**TOWER 2, LEVEL 23
DARLING PARK, 201 SUSSEX ST
SYDNEY NSW 2000**

16 January 2017

SSDA 7663 - TOYOTA SPARE PARTS WAREHOUSE AND DISTRIBUTION CENTRE - SITE 3B, OAKDALE SOUTH ESTATE

This letter provides a formal response to the matters raised in the submissions.

TOYOTA PARTS & ACCESSORIES FACILITY

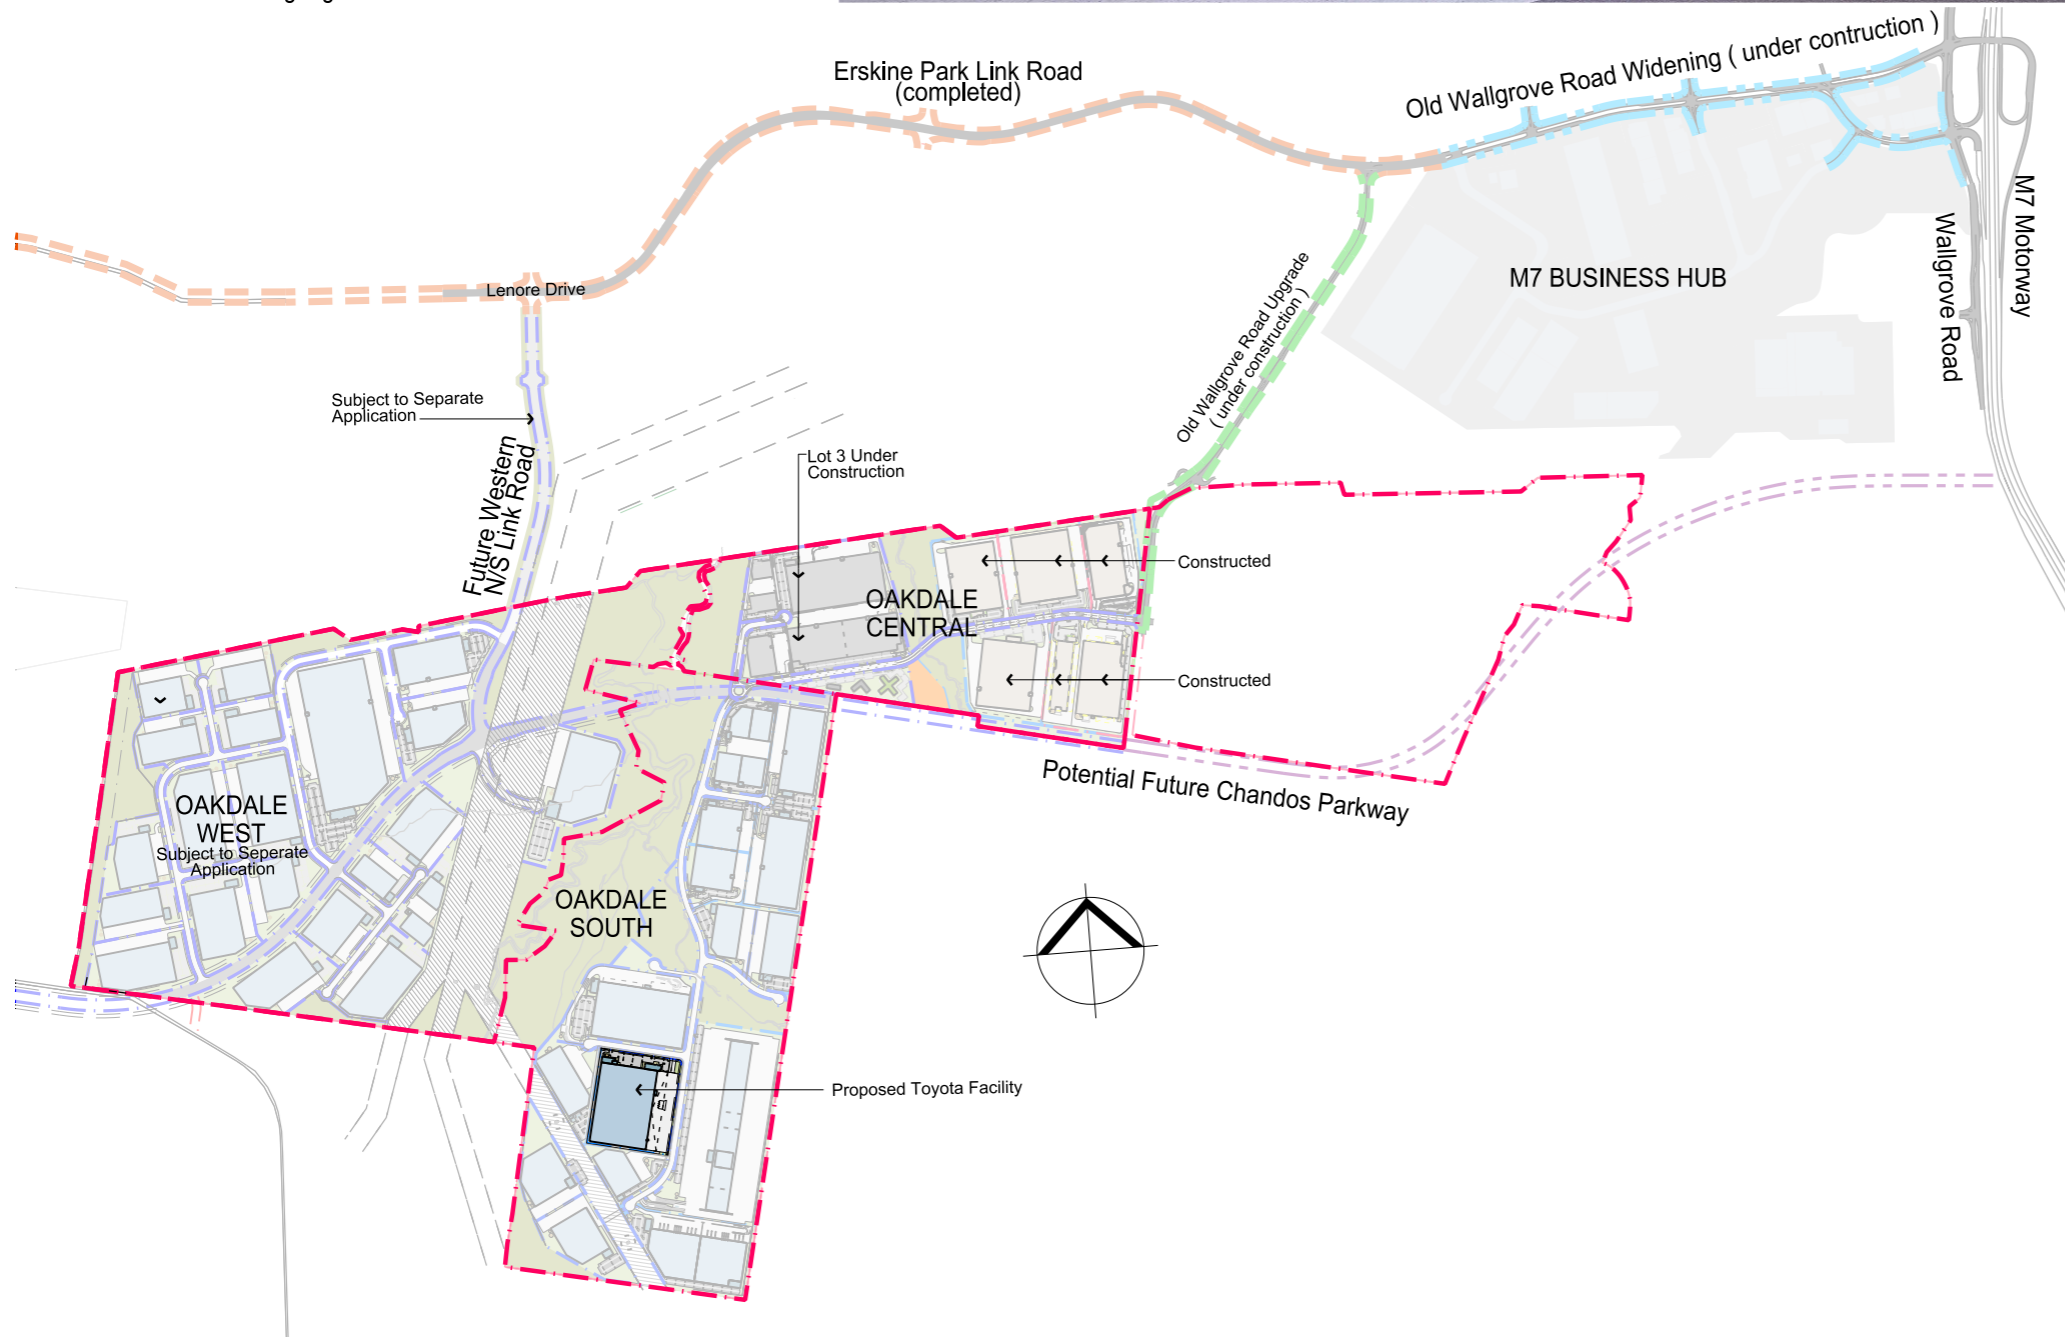
Matters Raised	Applicant consideration of matter/response
Department of Planning	
<u>Urban Design and Layout</u>	
<p>The primary frontage appears to be to Estate Road 4, and the loading dock occupies the secondary frontage to Estate Road 1, the most prominent frontage. Architectural/design control No. 5 of the Penrith Council Development Control Plan 2014 - Erskine Business Park requires loading docks to be located towards the rear of allotments and screened from view through physical and/or vegetation screening. Consideration should be given to relocating the loading dock to the western elevation.</p>	<p><u>Location of Building and Loading Dock</u></p> <p>The design of the Toyota Parts and distribution facility has been developed following extensive operational analysis and design development with the intent of achieving best practice across Toyota's global portfolio with respect to safety and operational efficiency.</p> <p>This process has been heavily informed by Toyota's well documented 'just in time' or 'lean' production systems (TPS) as well as the Toyota company commitment to 'Kaizan' (continuous improvement) following over 50 years of manufacturing cars in Australia.</p> <p>The fundamental design criteria for the orientation of the facility, including the location of the proposed loading docks has been informed by this operational analysis and includes:</p> <ul style="list-style-type: none"> • Warehouse proportions of 1:1.5 for maximum efficiency for movement and storage of parts in the warehouse and separation of man / machine for employee safety.

Matters Raised	Applicant consideration of matter/response
<p>Additionally, consideration should be given to providing a consistent setback on the eastern elevation with that of the adjacent Sigma site to the north.</p>	<ul style="list-style-type: none"> • The site layout and orientation for the adjacent Site 3A (Sigma) has been directly informed by Sigma's specific operational requirements. Given the differences in requirements between the end users and size / configuration of the development sites, it is not feasible nor practical to apply a one size fits all approach to development setbacks, noting that both sites comply with the numerical requirements approved in the site specific DCP. • The site specific DCP provides controls for the development of buildings within the OSE. The DCP requires a 7.5m building setback to Estate Roads and an average of 50% of this building setback to be landscaped along the frontage. This means that an average of 3.75m is required along the Estate Road frontages. • A continuous 3.8m landscape setback has been provided along the eastern boundary to Estate Road 1, with an increased landscape setback to the corner of Estate Road 1 and Estate Road 4, which is greater than 15m. This setback complies with the requirements of the site specific DCP and is consistent across both sites. • Perimeter tree planting has been provided as per the submitted landscape plans by Site Image which will provide adequate screening consistent with the approved landscape screening treatment approved across the estate under the SSD6917.

<p>Penrith City Council</p>	
<p><u>Layout and Orientation</u></p> <p>Council has previously raised concerns regarding the modified building concept for Precincts 3, 4 and 5. These concerns relate to the orientation of the warehouses, the location of parking areas and loading docks as well as a</p>	<ul style="list-style-type: none"> • We note that these comments are site wide and that concerns relating to Precincts 4 and 5 are not applicable to this SSDA. • The site specific DCP with which the proposal generally complies allows for flexibility in design to account for tenant needs. It is noted that the

The Erskine Business Park Section of Council's Development Control Plan (DCP) 2014 does not allow loading docks within the defined setback to any road frontage.	<ul style="list-style-type: none"> • A site specific DCP was approved under SSD 6917. This DCP is required to be adopted into Penrith DCP 2014 as per Condition B12 of the Concept and Stage 1 approval for SSD 6917. • The requirements of this control are that loading areas <i>should</i> be located towards the rear of the allotments and <i>where possible</i> screened. The proposed layout is justifiable for the following reasons.

Matters Raised	Applicant consideration of matter/response
<p>At a minimum the extent of landscaping should be increased along the eastern boundary to match the 15m setback to any road required by the Erskine Business Park Section of the DCP.</p>	<ul style="list-style-type: none"> – The operational requirements of Toyota require the loading area in the proposed location in order to provide two points of entry / egress to the hardstand to ensure one way traffic flow for safety and operational efficiency. – Landscaped screening will be provided along Estate Road 1 as per the landscape plans submitted with the SSDA. Site Image has confirmed that the proposed landscaping will provide adequate screening of the loading areas when viewed from Estate Road 1 (refer to landscape commentary above). – We note that there are several locations within Erskine Park area where the loading docks have frontages to the estate roads so this design response is not without precedence where operationally necessary (refer to Attachment 2). It is also noted that there is no through traffic to the south for the OSE and visitation is limited to staff and visitors. • The proposed setbacks have been addressed earlier in the response to DP&E comments. A landscaped setback of 14m is considered to be excessive as it exceeds the building setback requirements of the site specific DCP.

<p>The Swept Path Analysis prepared by Ason Group appears to show that a large expanse of the hardstand area facing Estate Road 1 will be utilised for external storage. This is not supported by Council on the basis of resulting in worsened visual prominence</p>	<ul style="list-style-type: none"> • The swept path analysis being referred to in this comment was based on an earlier revision of the site plan. The area is shown on the submitted architectural plans will accommodate overflow car parking if required.
<p><u>Signage</u></p>

Matters Raised	Applicant consideration of matter/response
	<ul style="list-style-type: none"> • A 30m deep awning to provide all weather loading / unloading for the full range of vehicles up to B-doubles and ensures safety and amenity for employees and truck drivers for loading / unloading. • A generous 63m deep hardstand enables a safe working environment for passing and manoeuvring trucks with separate entry and exit points for one way flow of vehicles on the hardstand and which accommodates on site queuing. • Providing clear separation between cars and heavy vehicle access points. The main office faces north and is co-located with car parking areas to eliminate pedestrian / vehicular conflict and to provide legible access from the office for staff and the loading docks facing east. • The building orientation ensures protection from adverse weather conditions and as such significantly improves overall health and safety and sustainability for Toyota staff. Additional design measures include: <ul style="list-style-type: none"> – Minimising the warehouse openings to the north and west to reduce impact of solar gain and high strength winds, and – Minimising the warehouse openings to the south and west to reduce the impact of cold winds and driving rain. – Providing a north facing office which optimises natural light for the office staff and improving the overall internal amenity and energy efficiency. • The office orientation also maximises Toyota's corporate exposure to the north-east corner and provides an attractive and professional building presentation to the street as show in the submitted photomontage.

Matters Raised	Applicant consideration of matter/response
	<p>The above criteria are essential to meet the operational needs of Toyota and are a fundamental requirement for selection of this estate to accommodate this facility. This has resulted in the proposed orientation and configuration of the facility thus necessitating the loading docks facing Estate Road 1.</p> <p>Vegetative Screening</p> <p>The Landscape Architect has confirmed that the species selection will ensure that the loading dock areas will be effectively screened thereby demonstrating consistency with this control. Site Image Landscape Architects confirms:</p> <p><i>“Planting proposed along the Estate Road 1 consist of groups of native tree planting, groups of shrubs with complementing groundcovers. Groups of Corymbia maculata (maure height x width) 15m x 7m trees, are proposed along this entire frontage. Over time, providing a high level screening and softening of the proposed built form. To ensure screening at lower level, i.e 1-3 metres, Large groups of Viburnum odoratissimum shall be planted across the extent of this boundary. Further to this a combination of Pennisetum ‘Nafray’, Gazania tomentosa, and Trachelospermum jasminoides are proposed to ensure a green and softened interface.”</i></p> <ul style="list-style-type: none"> • We note that several developments in the Erskine Park area have loading docks fronting estate roads this includes Grady Crescent and Lockwood Road in Erskine Park and as such not without precedent within this industrial precinct where operationally required (refer to Attachment 2).

Matters Raised	Applicant consideration of matter/response
<p>the visual impact of loading docks, the overall visual amenity of the estate would improve and the aims and objectives of the broader estate would be realised.</p>	<p>proposed master plan is the only option which can acceptably satisfy both Toyota and Sigma's specific operational requirements.</p> <ul style="list-style-type: none"> • Whilst it is acknowledged that active frontages would be a desirable urban design outcome and have been achieved to the extent possible, the importance of the OSE as a critical component of a strategically important employment hub, serving the direct and indirect needs of the growing Western Sydney region, including the future proposed airport at Badgerys Creek cannot be understated. • It is emphasised that allowing end users to tailor their designs per their specific operational requirements is critical to attracting long term occupants and therefore securing the economic prosperity of the WSEA. • The proposed elevations are consistent with the façade treatments implemented at Oakdale Central. The elevations reflect a consistent design language and an attractive and holistic presentation across the Oakdale precinct. • Architectural features and landscaping are proposed to break up large expanses of building mass which are consistent with the treatment approved under SSD 6917. Providing varied building and landscape setbacks also contributes to improving the overall visual amenity and building articulation.

Matters Raised	Applicant consideration of matter/response
reduction in land available for landscaping relative to the previously approved application.	<p>proposed development complies with the setbacks provided within this DCP.</p> <ul style="list-style-type: none"> • Site 3B is the most suitable for Toyota's operational requirements as it has two road frontages. Toyota requires two points of entry / egress directly to the hardstand to enable one way traffic flow and for the safety and operational efficiency of the hardstand area. • The office has a northerly aspect and presents a design of architectural merit to the frontage of Estate Road 4 and at the north east corner of the site. This is illustrated clearly in the submitted photomontage.
Concerns regarding the layout of development under the proposed modified concept plan given the large expanse of blank walls and building mass facing prominent estate roads. The proposed development shows little regard for any presentation to its frontage to Estate Road 01.	<ul style="list-style-type: none"> • Prominent elevations fronting the street or public reserves are consistent with the façade treatments approved by the Department under the original SSD 6917. The building is setback significantly (65m) from the street frontage. The setback reduces the appearance of bulk from this frontage. • Landscaping, including trees and shrubs, along this frontage further reduce any unacceptable impact to the Estate Road 1 frontage (refer to Estate Road 01 planting / screening description above). • The ancillary office is also located along the main frontage, contributing to its articulation.

02 EAST ELEVATION
WAREHOUSE 3B

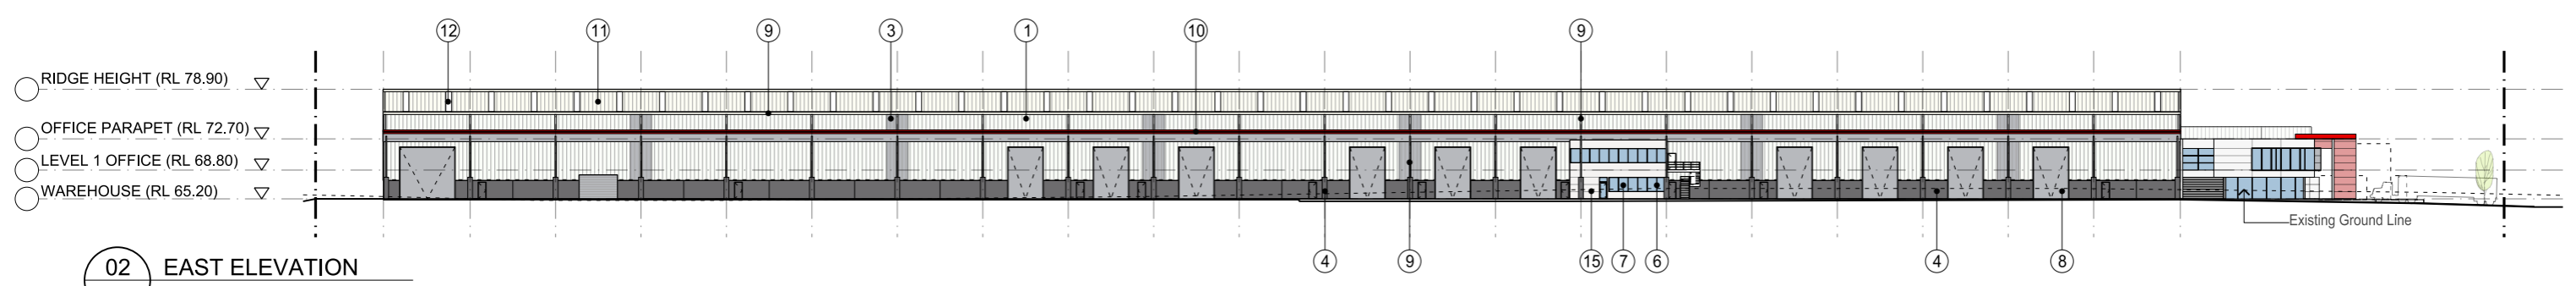
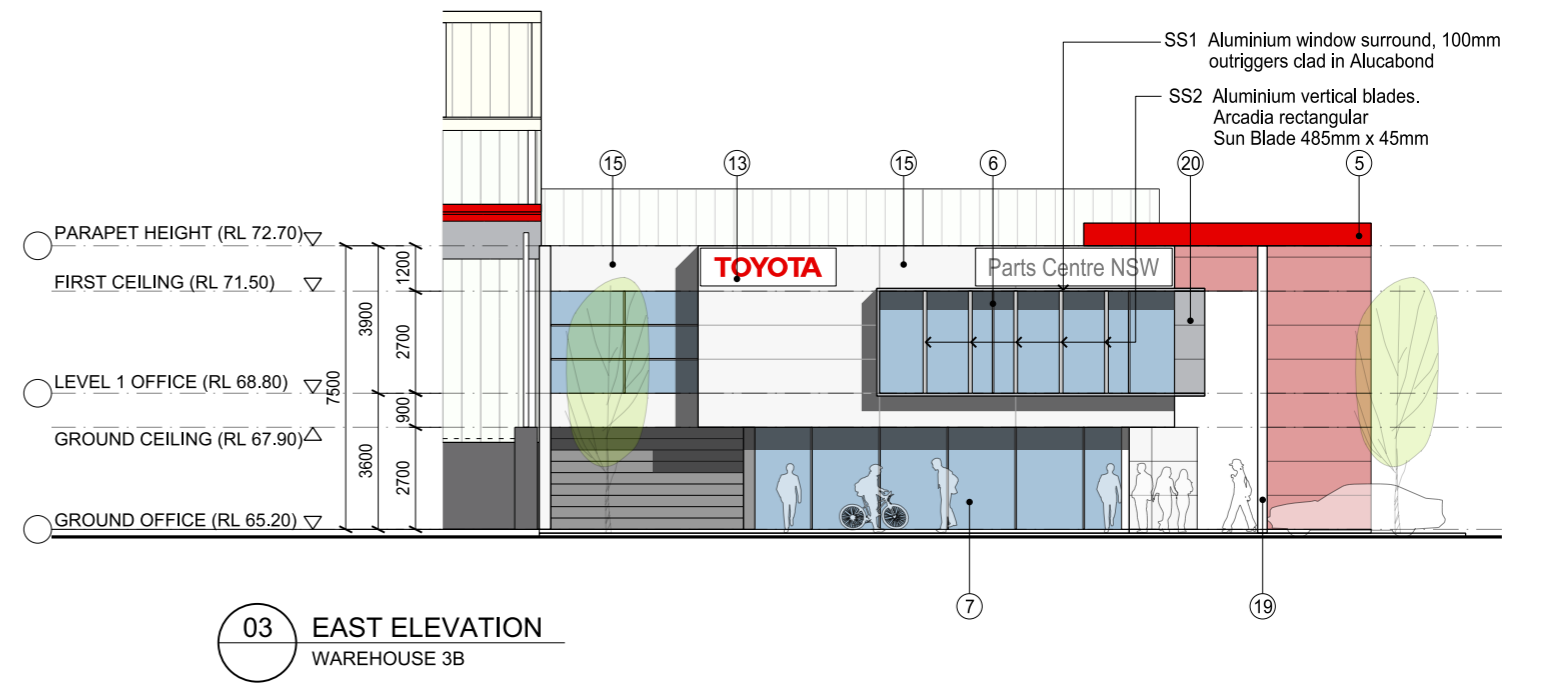
<p>The Department has some concerns due to these unresolved urban design matters. As the Oakdale South Estate is in its early stages of development it is important to set a positive precedent for future warehousing developments. By encouraging warehouse buildings that address primary frontages, activate streetscapes, provide architectural interest and reduce</p>	<ul style="list-style-type: none"> • The proposed buildings are operational facilities and while active frontages are sought and achieved where possible within the OSE, the operational requirements of the end-users have necessarily been prioritized to ensure that the facility can function in the manner required. Several alternative master plan options were considered however the
